**Subject:** WA/89/26/NMA – Supplementary representation: approved baseline, garage clarification and cumulative assessment

Further to my objection of 18th September concerning WA/89/26/NMA, I have continued to reconcile the submitted amendment package against the final drawings and documents approved under WA/52/24/RES.

scheme: Land West of Yapton Lane, Walberton
client: Doswell
drawing: Hard Landscape Proposals
date: July 2026
scale: 1:200@A1
drawing no: PRI25259 12 Sheet 1
drawn: RH checked: DKM

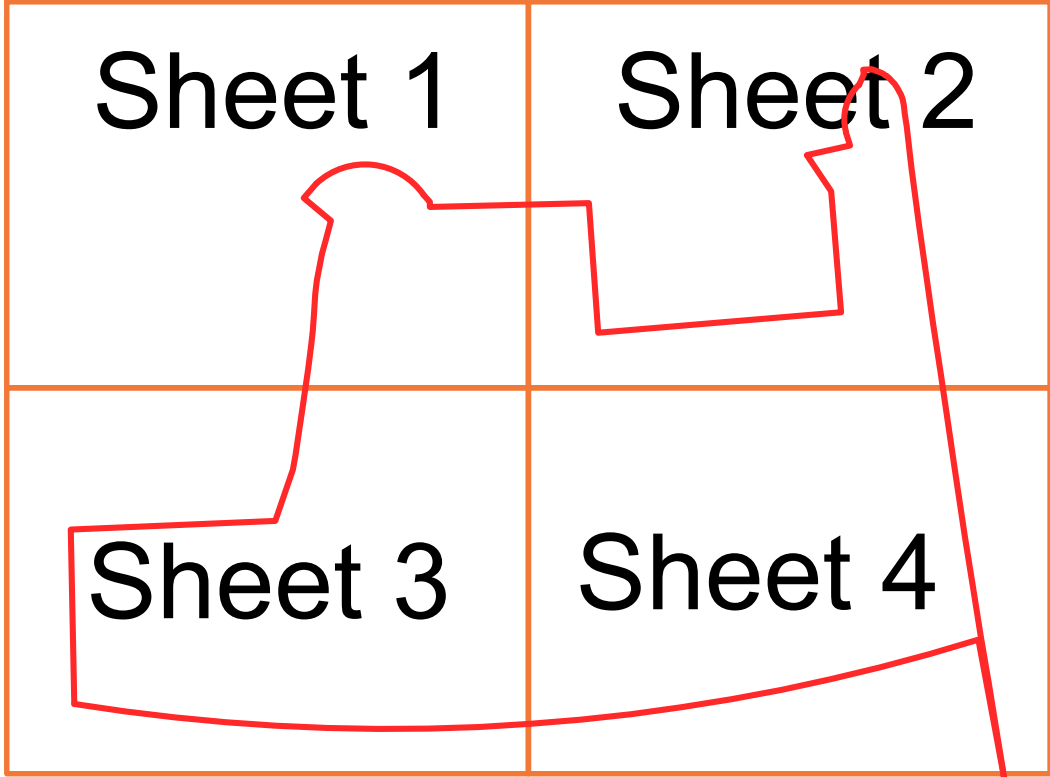
The approved RES officer report records that a **1.1m high estate railing fence** was to be provided along the southern elevation specifically so that the boundary would not appear enclosed and would retain views across the adjoining field. The report separately identifies **1.1m post-and-rail fencing behind Plots 17–21 adjoining the Conservation Area**. The two treatments therefore performed distinct roles within the approved landscape design.

WA/89/26/NMA expressly proposes replacing estate railings with post-and-rail fencing, and the proposed site-layout legend now identifies **“TIMBER POST AND RAIL FENCE”** where the approved site-layout legend identified **“ESTATE RAILINGS.”**

The proposed site layout does not itself establish the height, rail arrangement, detailed construction or whether stock mesh, hedging or another associated treatment forms part of that replacement.

That is significant because post-and-rail fencing is not itself a single uniform treatment within the approved landscape documentation. The approved soft-landscape specification, for example, also describes 1.2m rounded post-and-rail fencing with three cross rails and stock fencing for native planting areas.

Again, I recognise that A/165/23/NMA is scheme-specific and not a precedent. However, I would be grateful if the officer assessment of WA/89/26/NMA could identify precisely which approved lengths of estate railing are being replaced, the proposed post-and-rail specification, and the consequential drawings which demonstrate the resulting boundary treatment and its effect upon the openness and views which the approved estate railings were expressly intended to preserve.
